Response to Planning Application

Application ref: BN/46/25/PL

Description: Application for construction of 10 No dwellings with new access from Wandleys Lane, landscaping and areas for ecology & amenity space. This application is a Departure from the Development Plan and is in CIL Zone 3 and is CIL Liable as new dwellings.

Location: Land South of Wandleys Lane Eastergate PO20 3SE

**PROPOSED SITE PLAN
(1:200)**

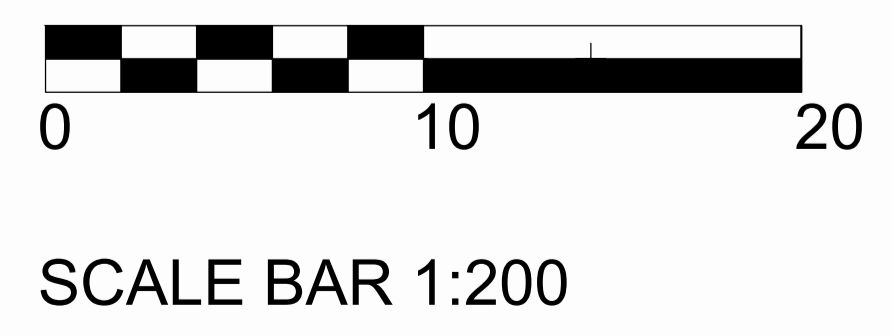
The Proposed Site Plan 05 Rev A and Proposed Landscape Strategy Plan 16A shows 10no dwellings within the proposals. Included within the proposals is indicated Ecology Areas/Open Space, located mainly to the periphery of the development, adjacent to Wandleys Lane which largely accommodate the existing trees in these areas.

The LAP provision onsite should cater for unequipped natural play LAP to include such features as landform, boulders or logs, seat. There does not appear to be any provision for LAP area indicated on the submitted drawings.

Recommend no objection on landscape grounds subject to future submission of landscape detail and confirmation of inclusion of LAP play land provision under this application BN/46/25/PL.
